Final Report - Corrections Required **Application No. ANEX-24-0004**

Description : Matrix Design Group on behalf of Colorado Springs Equities LLC is submitting a serial annexation petition for seven parcels and Land Use Plan/Rezoning exhibit for a portion of the subdivision known as Rock Creek Mesa.

Document Filename : Rock Creek Mesa Addition No 3_Legal Description_V3_5-13-24

ANNEXATION PLAT
ROCK CREEK MESA ADDITION NO. 3

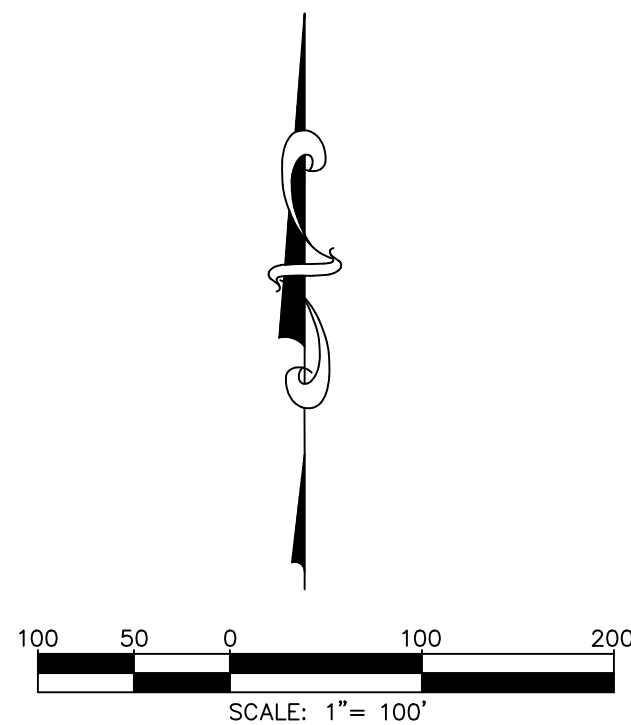
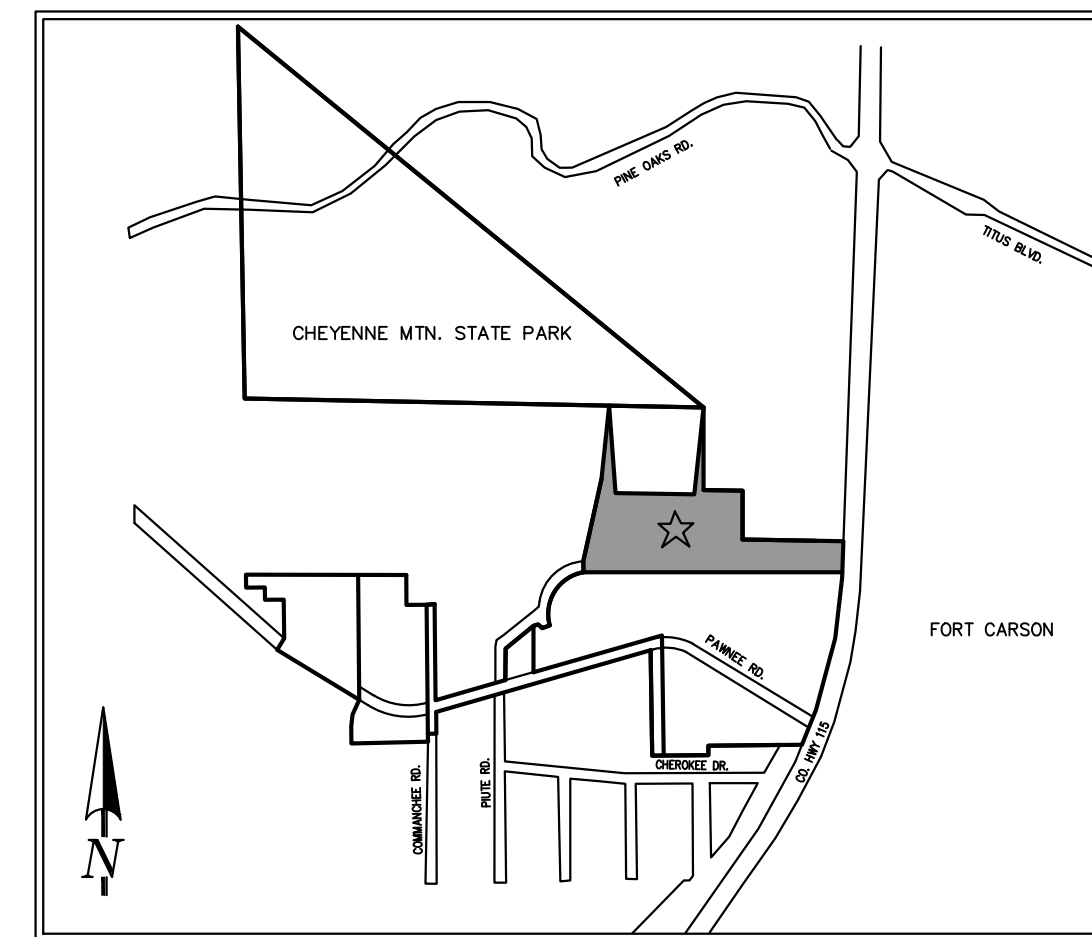
Comment ID	Page Reference	Reviewer : Department	Review Comments
54	1	Gabe Sevigny : Planning	update legal description per Surveyor comments
